**OXFORDSHIRE COUNTY COUNCIL'S RESPONSE TO CONSULTATION ON THE
FOLLOWING DEVELOPMENT PROPOSAL**

Application no: 14/01366/REM

Proposal: Reserved Matters Application to 10/01642/OUT - Erection of 74 dwellings with associated car-parking, infrastructure and public open space

Location: Former Building 32 & Adj Land At Heyford Park Camp Road Upper Heyford Bicester OX25 5LX

DRAWING TITLE **SITE LAYOUT**

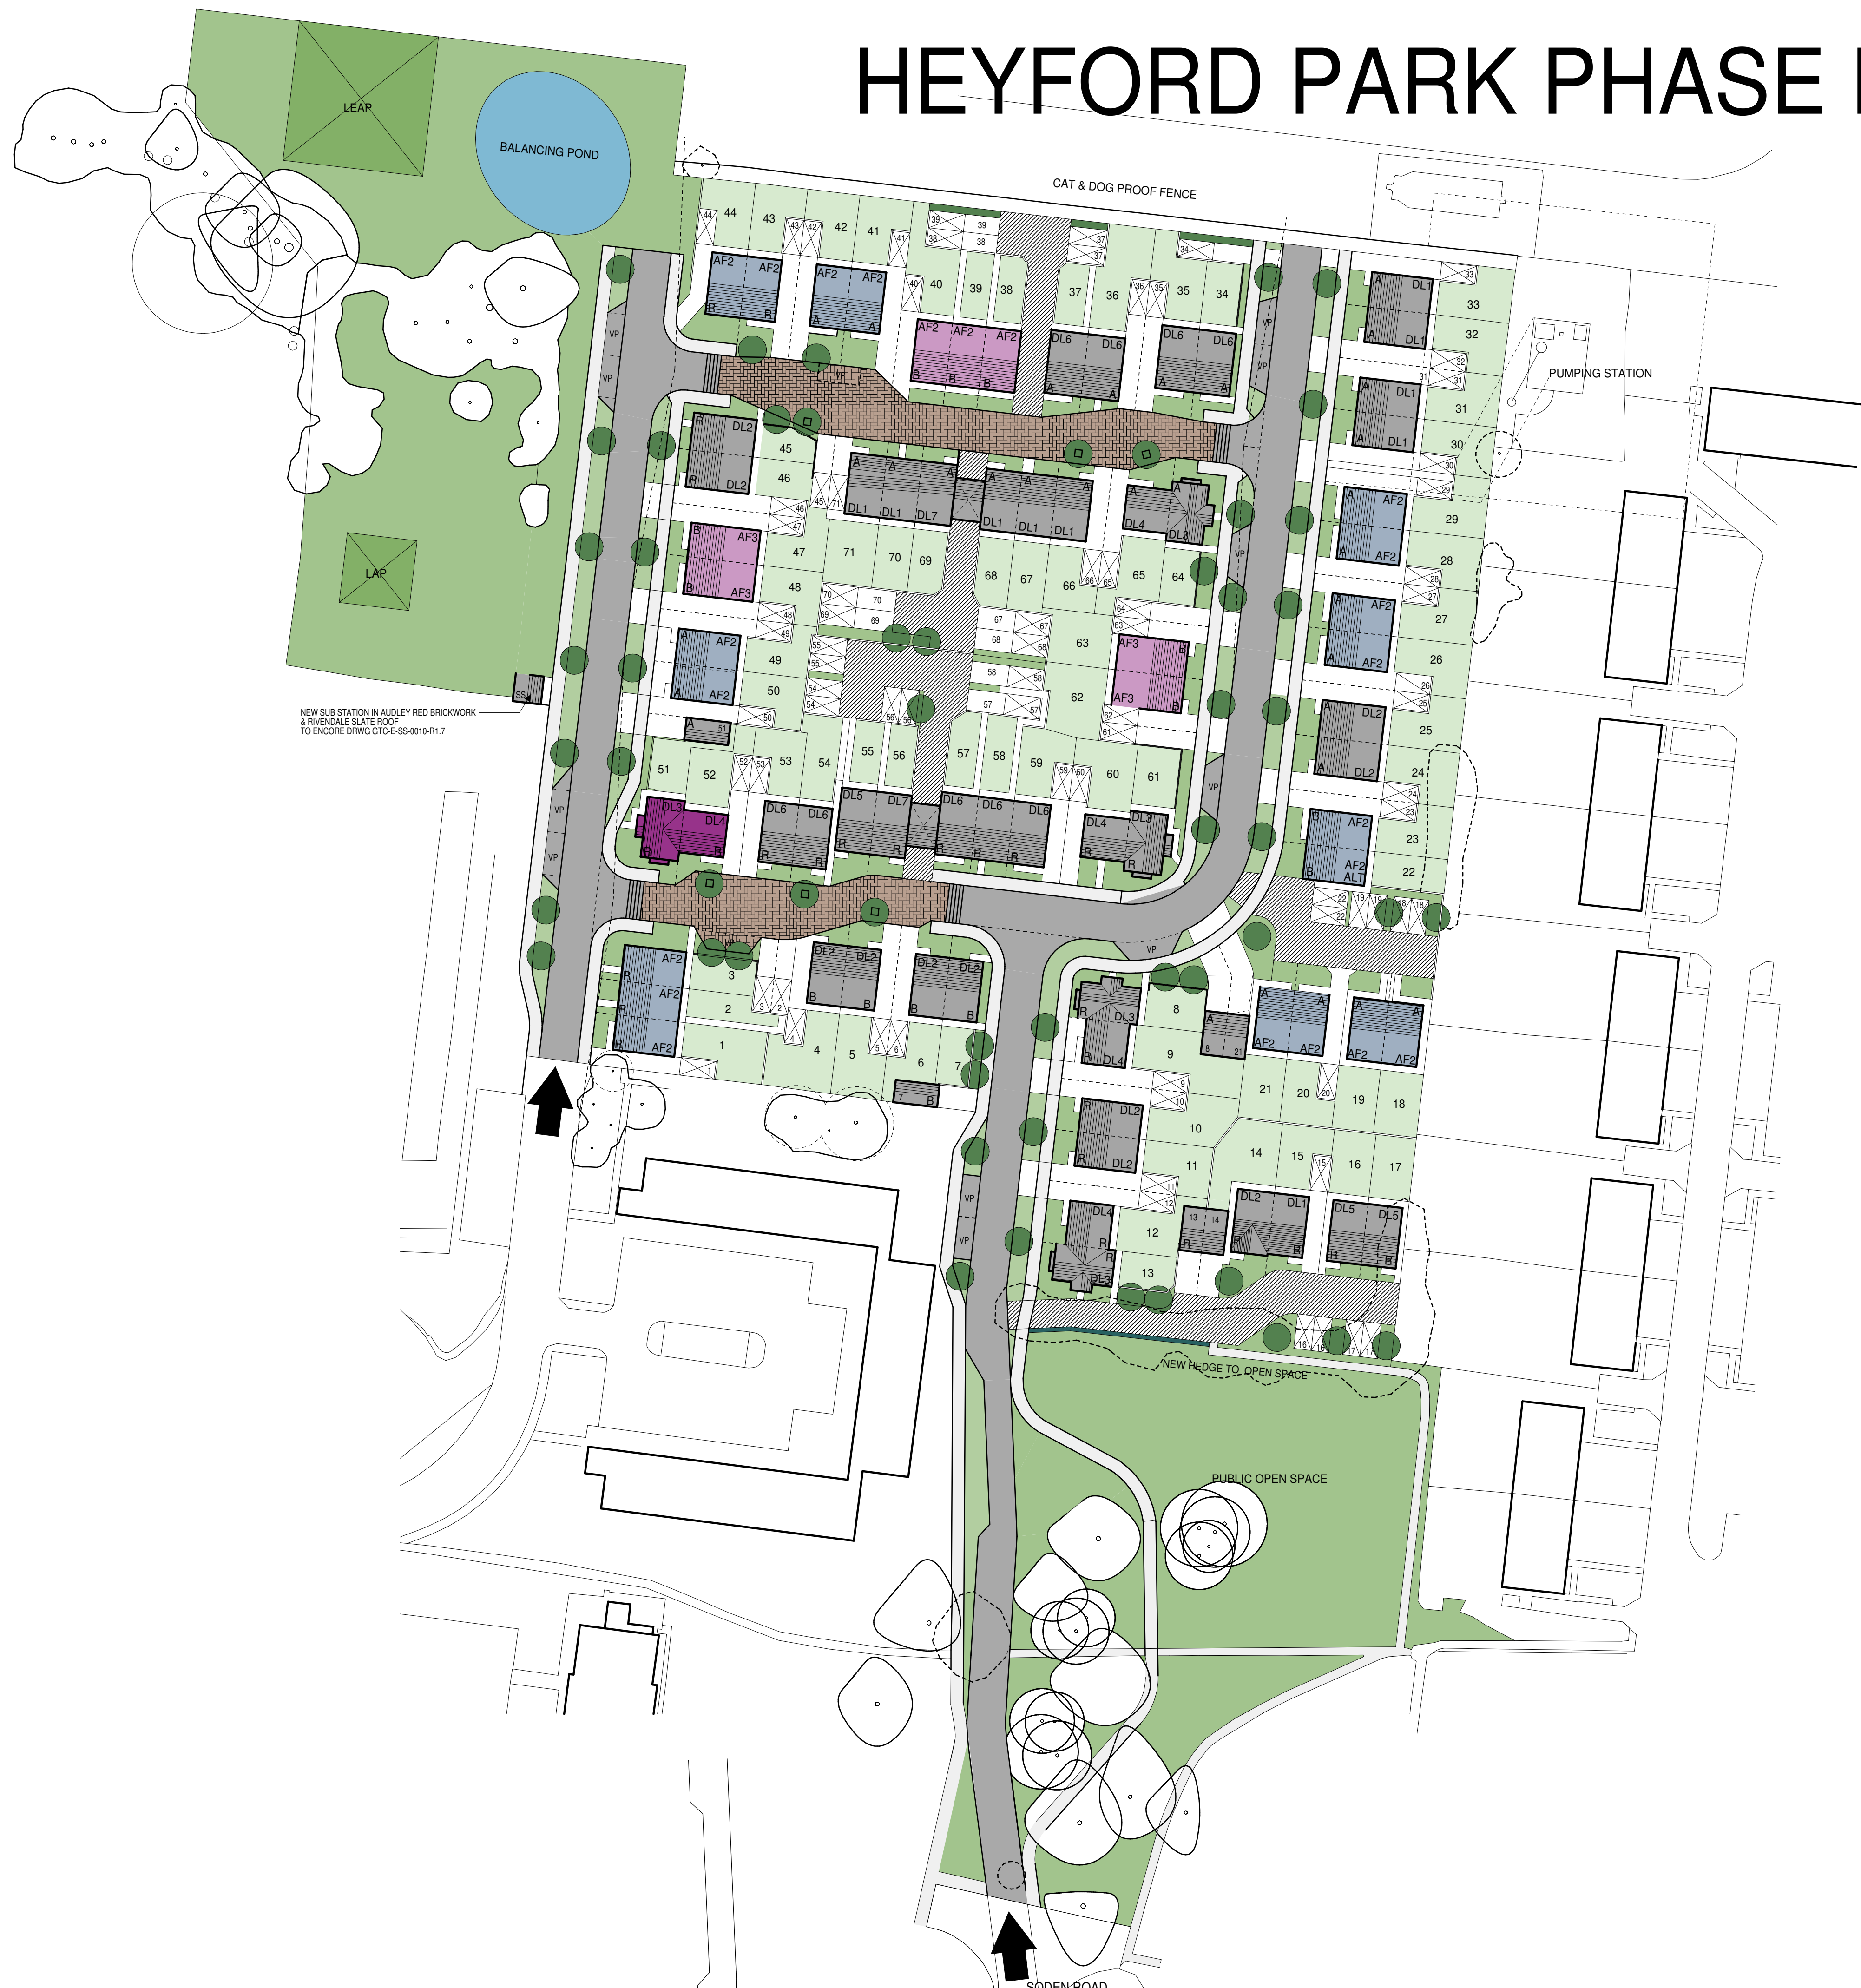
The following is noted in relation to parking arrangements presented on drawing No.014/085/SP/C.

- Plot 17 east and Plot 18 east appear to be close enough to the edge of the driveway for it to be not possible to turn and exit the driveway in forward gear.
- Plot 54 does not appear to have any allocated parking spaces.
- The visitor parking outside plots 4 and 60 is too close to the main estate road intersection and should be moved or removed.

These aspects will need to be amended accordingly and shown on a revised plan. Swept path analysis for an estate car will need to be provided to demonstrate that it is possible for cars at all parking spaces on private driveways can access and egress the estate road in a forward gear. The swept path of a refuse vehicle accessing all areas of the estate road will also need to be shown on the plan.

All parking spaces will need to be provided in accordance with OCC's minimum dimensions. These require a minimum 5.0m in length with width varying from 2.5m to 2.9m depending on obstructions. The spaces on Drawing No.014/085/SP/C do not appear to conform to these standards.

The key to Drawing No.014/085/SP does not specifically identify a pedestrian footway. However, it is assumed that it is represented by the pale grey area adjacent to the carriageway. This surface does not penetrate the north eastern part of the development site. This arrangement will need to be amended such that all dwellings are accessible to pedestrians via a footway.

The estate road will need to be of a design and layout such that it can be traversed by a standard size refuse vehicle. This will need to be demonstrated by vehicle swept path analysis on a scale drawing.
